RE: 4G Farms Short Plat (SP-24-00001) – Correction

Parcel# 955540

It was brought to our attention by Kittitas County Public Works that there is a file name discrepancy on the survey for this project that will need to be corrected. The submitted survey is titled "Walker Drive Short Plat." On all other correspondence and documentation for this project, the project is identified as "4G Farms Short Plat."

WALKER DRIVE SHORT PLAT
 PART OF SECTION 32,
 T. 18 N., R. 19 E., W.M.
 KITTITAS COUNTY, WASHINGTON

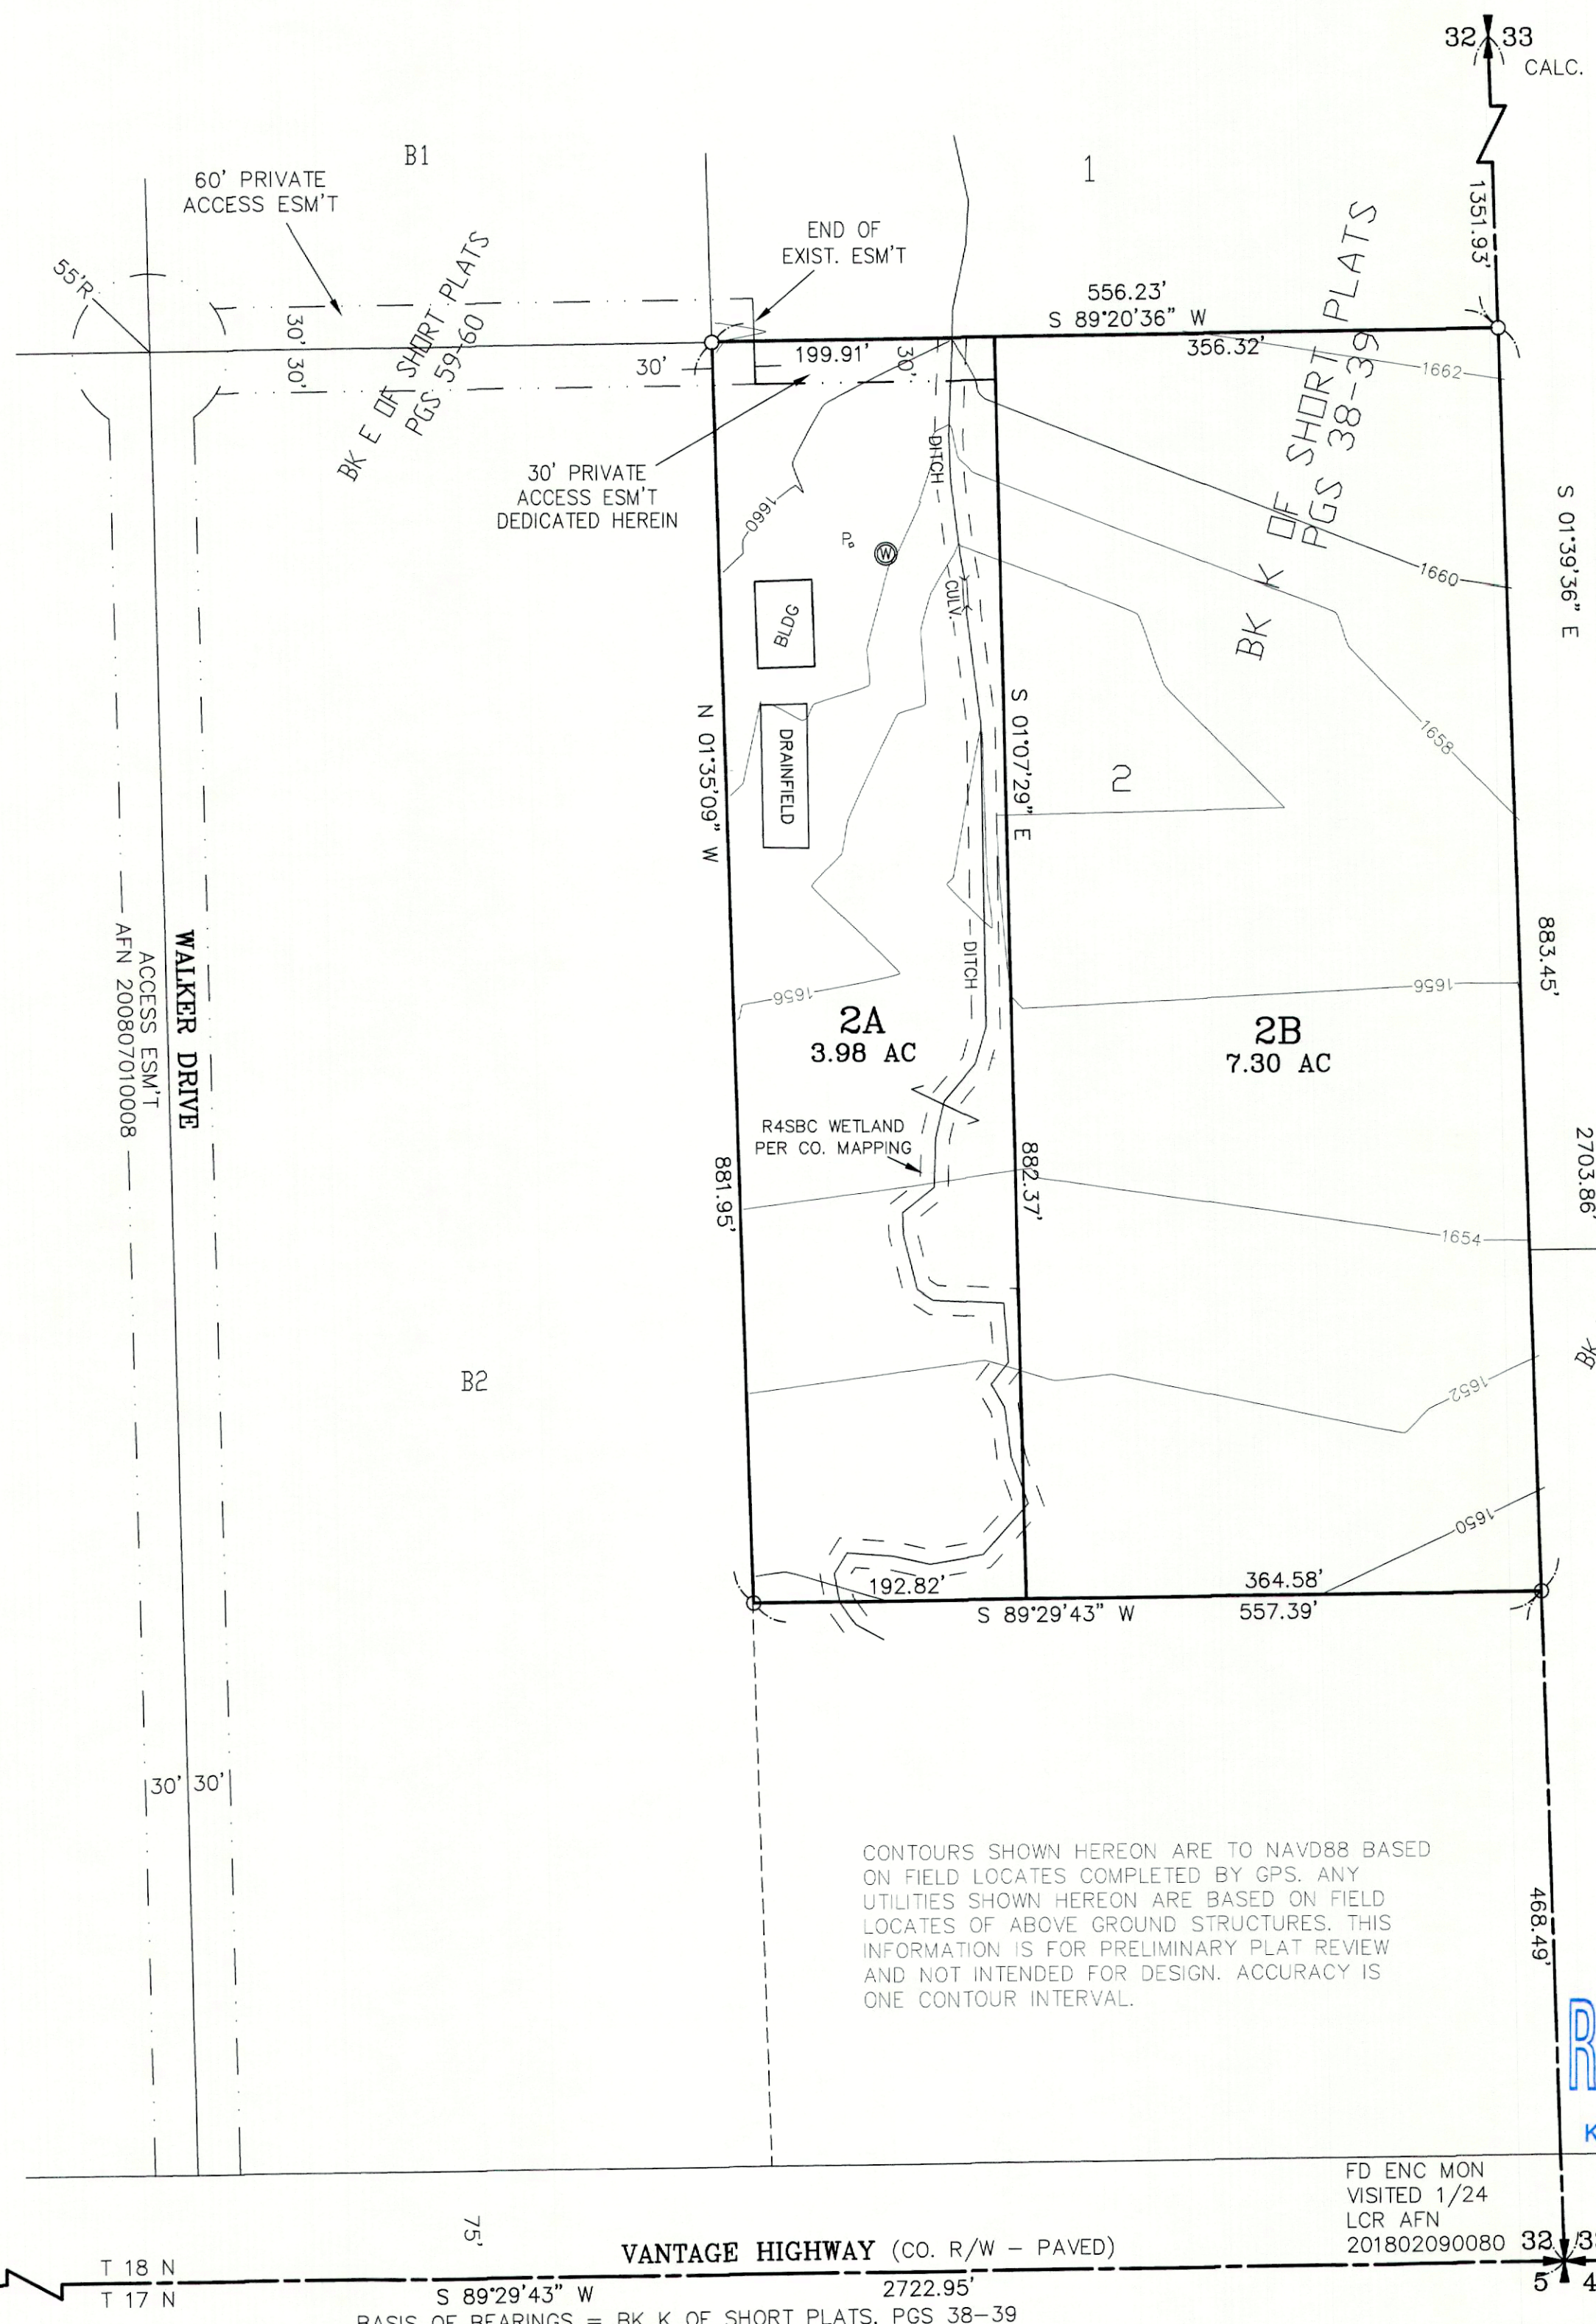
Please correct the name on the survey and all future documentation.
